AQUIND INTERCONNECTOR
DCO Parameters Index Document

Document Ref: 7.7.5

PINS Ref.: EN020022

DATE: 6 OCTOBER 2020

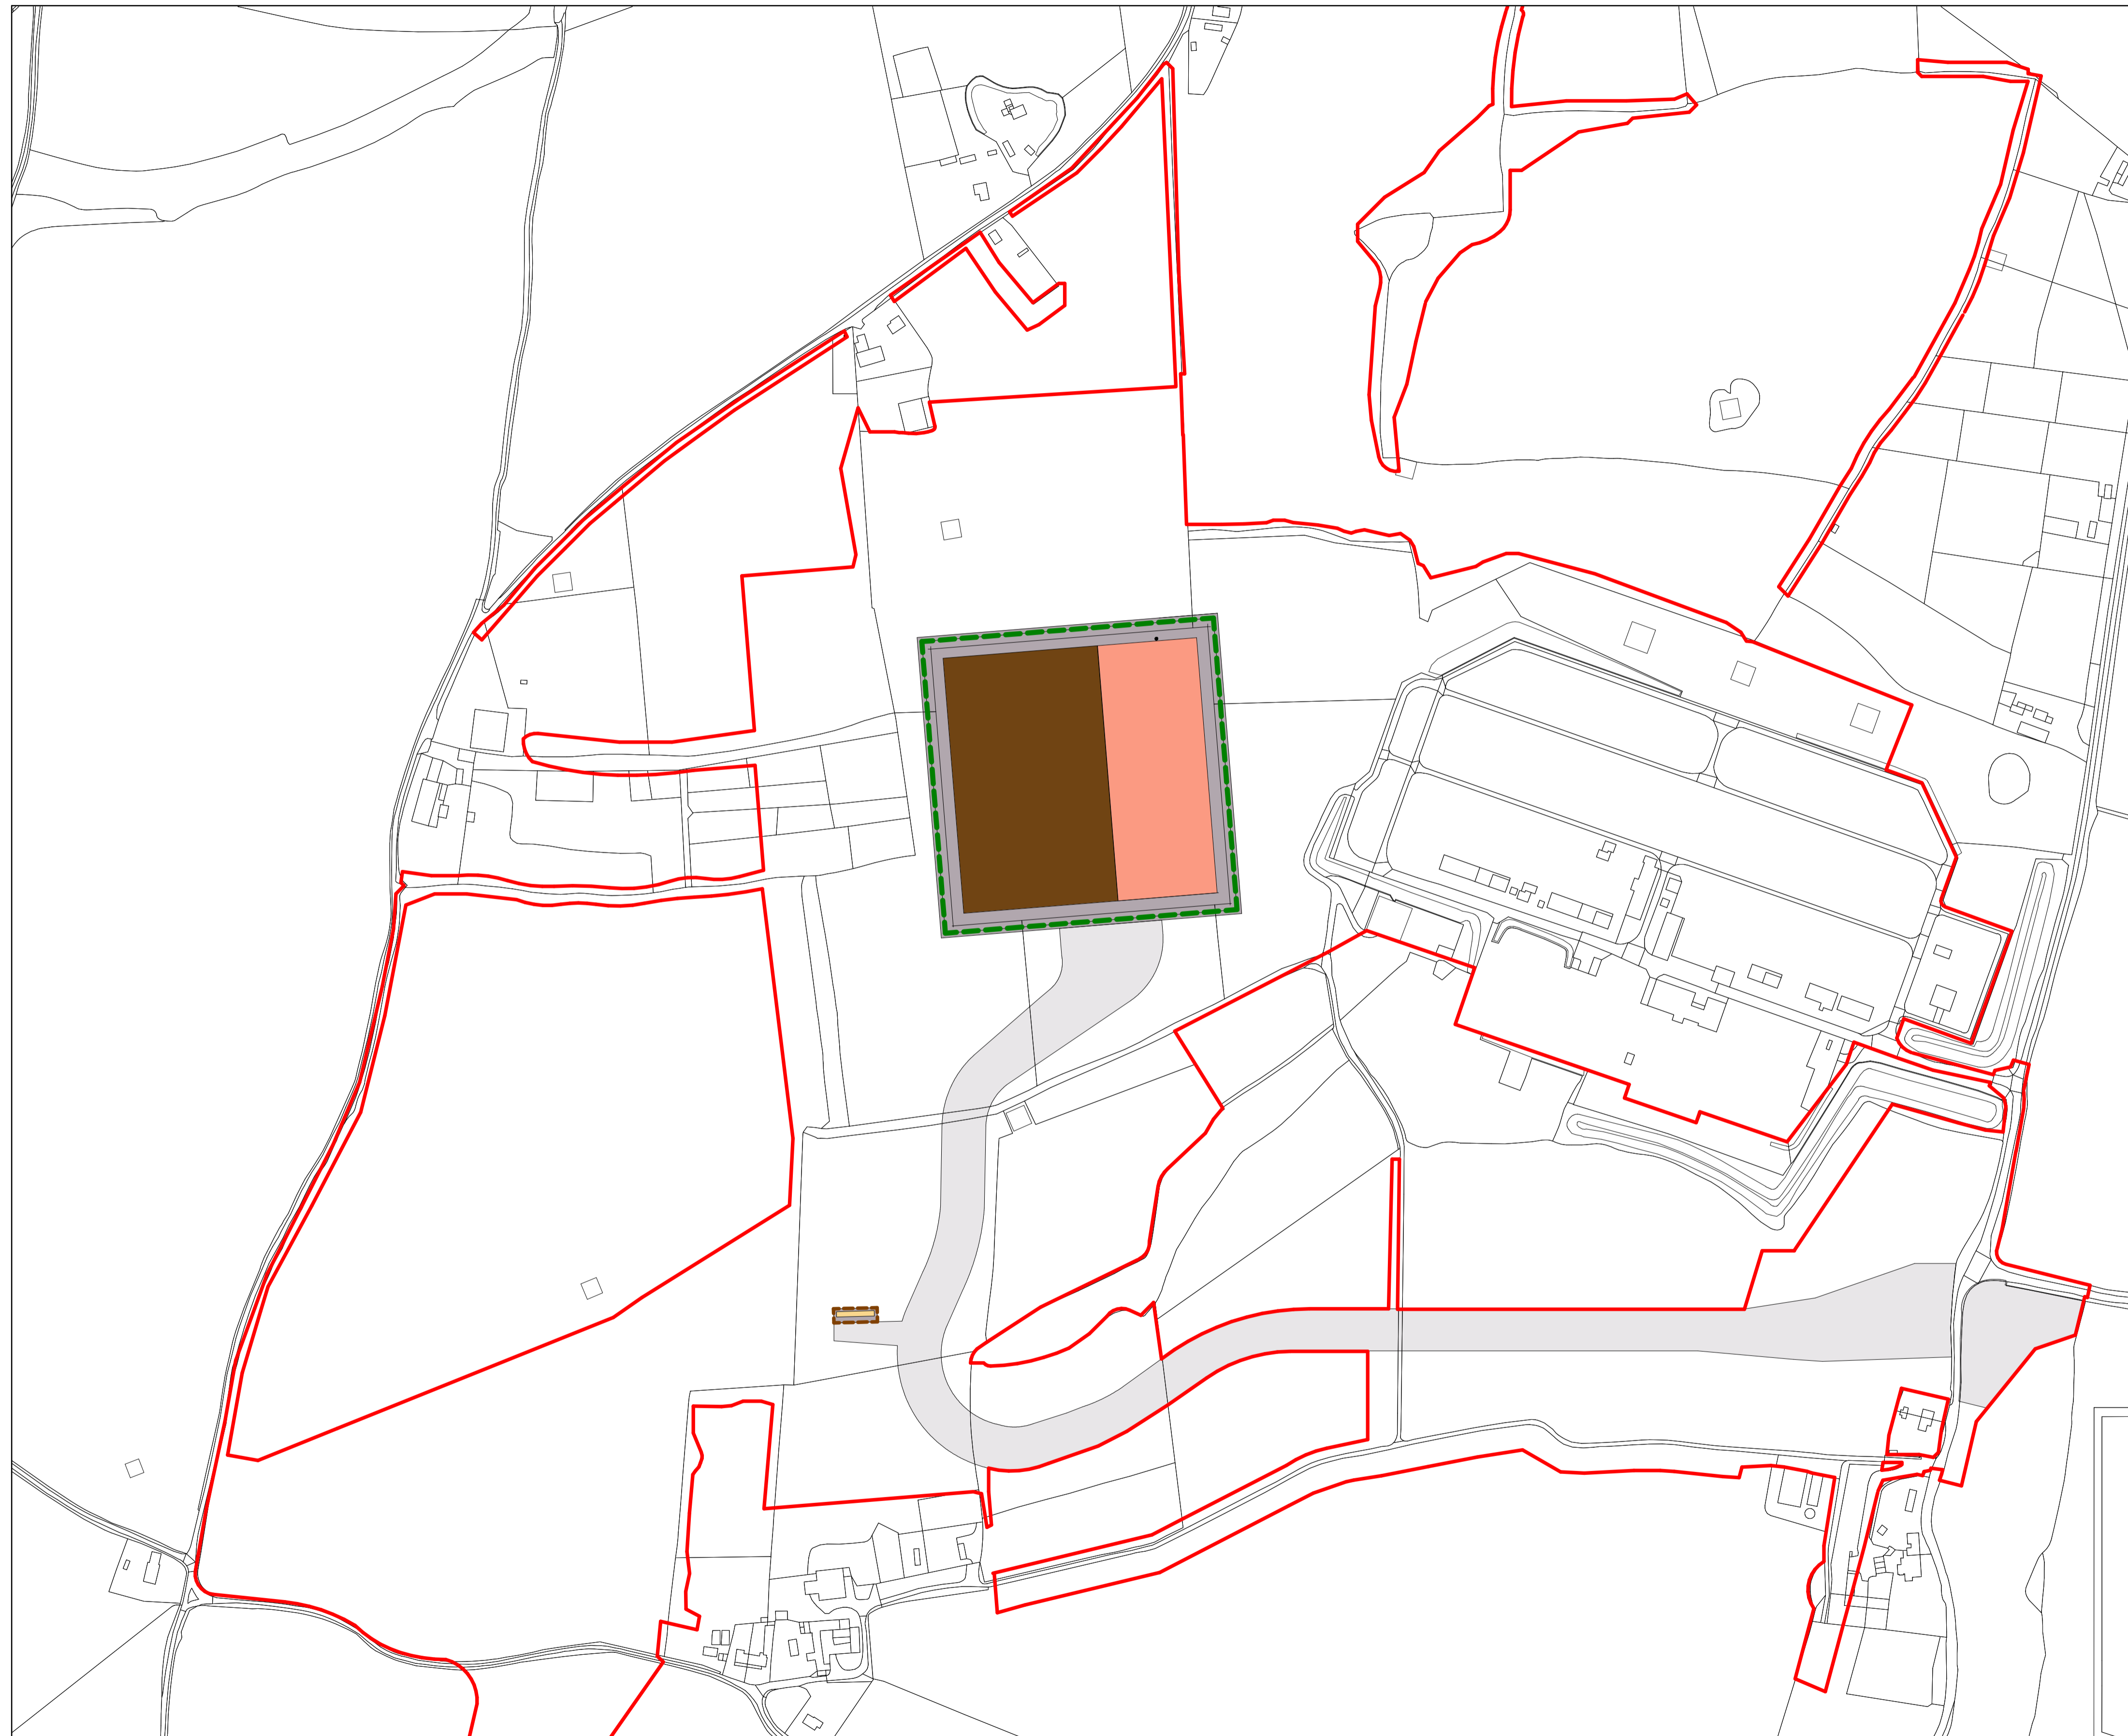
Paragraph 3.6.3.2	The proposed Converter Station area footprint is 200 m x 200 m (4 ha).	Requirement 5 to the dDCO requires compliance with Converter Station and Telecommunications Buildings Parameter Plans. The Converter Station and	No resolution required as position aligned.

Document Location	Parameter stated in ES	Parameter stated within Draft DCO	Resolution
		Telecommunications Buildings Parameter Plans identify a 200m x 200m footprint within which the Converter Station and associated equipment are to be located.	
Paragraph 3.6.3.7	<p>This conversion equipment is housed indoors, within the two Converter Buildings.</p> <p>Each Converter Building will comprise of a steel structural frame and will measure approximately 90 m in length, 50 m in width and up to a maximum of 26 m in height to be measured from finished ground floor slab level.</p>	<p>Work No. 2 in Schedule 1 to dDCO states 2 converter hall buildings.</p> <p>Table WN2 within the dDCO secures the maximum parameters for the Converter Halls as 90m x 50m x 26m.</p> <p>The maximum AOD height of the Converter Hall Buildings is also now restricted by an addition to the Converter Station and Telecommunications Buildings Parameter Plans, which provides the converter halls may not be above 111.10m AOD in height.</p>	No resolution required as position aligned, though clarification included on The Converter Station and Telecommunications Buildings Parameter Plans in relation to maximum AOD height.

Paragraph 3.6.3.9	The Control Building (item 2 in Plate 3.7) ... will comprise a two-storey building with steel frame structure ... with a maximum overall height of 15 m, to be measured from finished ground floor slab level.	Table WN2 at Requirement 5 to the dDCO does not state control building maximum parameters.	Draft DCO updated to confirm maximum parameters of Control Building as 26m in length x 50m in width x 15m in height.
Paragraph 3.6.3.11	The spare parts building (item 9 in Plate 3.7) will comprise a maximum 15 m high single storey steel frame structure ... and a 2.4 m high internal perimeter for robustness.	No parameters stated in dDCO.	Draft DCO updated to confirm maximum parameters for the spares building of 27m in length x 25m in width x 15m in height and reference an internal perimeter fence for the spares building with a maximum height of 2.4m.
Paragraph 3.6.3.12	The lightning masts can generally be up to 4 m taller than the tallest building, are tall, narrow structures, with catenary wiring strung between them to shield the outdoor equipment from direct lightning strikes.	<p>Maximum height of lightning masts stated to be 30m in Table WN2 at Requirement 5 to dDCO.</p> <p>The position is also confirmed on the Converter Station and Telecommunications Buildings Parameter Plans, which Requirement 5 requires compliance with.</p>	No resolution required as position aligned.

Paragraph 3.6.3.43	To keep the excavation within structureless chalk strata to mitigate contamination of the aquifer, 84.80m AOD has been proposed as Converter Station general finished level. Following initial Flood Risk assessment, the Converter Building finished floor level has been proposed to be 85.10m AOD (300mm above finished site level). Therefore, for the basis of the EIA assessment, 85.10m AOD has been used.	The Converter Station and Telecommunications Buildings Parameter Plans confirm heights indicated are heights above finished ground floor slab level of +85.100 AOD. Whilst this level is indicative, it confirms the assessment is aligned with the parameters regarding heights of buildings which this ground floor level is relevant to.	No resolution required as position aligned.
Paragraph 3.6.4.1	The Onshore Cable Corridor represents the maximum extent of the area within which the Onshore Cables may be located, otherwise described as the limits of deviation.	The Onshore Cable Corridor aligns with the extent of the limits of deviation shown for Work No. 4 on the Works Plans (APP-010).	No resolution required as position aligned.
